A46 Cov_8May_ISH1_PT2

Thank you. So we've finished agenda item seven. We're now moving to the next agenda item which is eight and flood risk assessment. So the first item to be discussed will be the submitted flood risk assessment. And my first question is directed to Coventry City Council.

Mr. Smith, thank you. On that basis, we move on to the next the next item on this agenda item. And this concerns the pool Flood Mitigation scheme, um, to the applicant and to Coventry City Council. I'll be posing questions to you both on your approaches to assessing reservoir flood risk. I'll direct my questions first to the city council and then to the applicant. Oh that's okay.

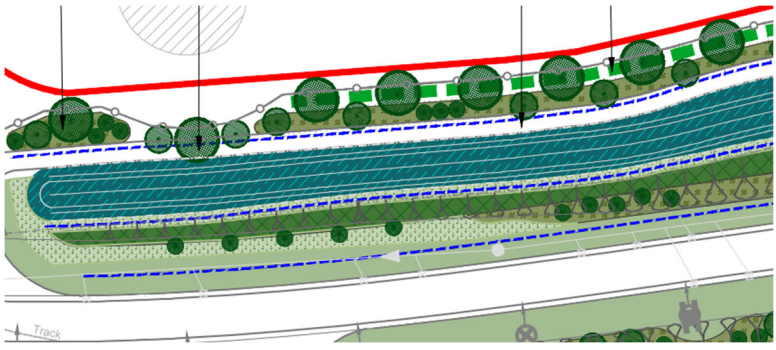
The initial proposal showed, um, in excess of 75% reduction in the height of this, uh, this embankment between the pool and the A46. But following challenge and further discussion, then, the

proposal has now been presented to us following a site visit to understand the sensitivity of sensitivity of it, that the proposal has now been presented, where the reduction in earthworks is a significant asset, sitting around 50% reduction, and this is considered to be more appropriate.

Hence, what came forward was a change to the earthworks to ensure that there is more earthworks remaining. Uh, to to show that there is now, um, better resistance to breach flooding than there was in the previous scheme.

We are satisfied that there is an increase in the height of the Bund. And there is more resilience to the city and the A46.

Mitigation measures being the change to the scheme that was originally presented to us, such now showing that the earthworks are higher. So that mitigation measure is something that we are happy to accept.
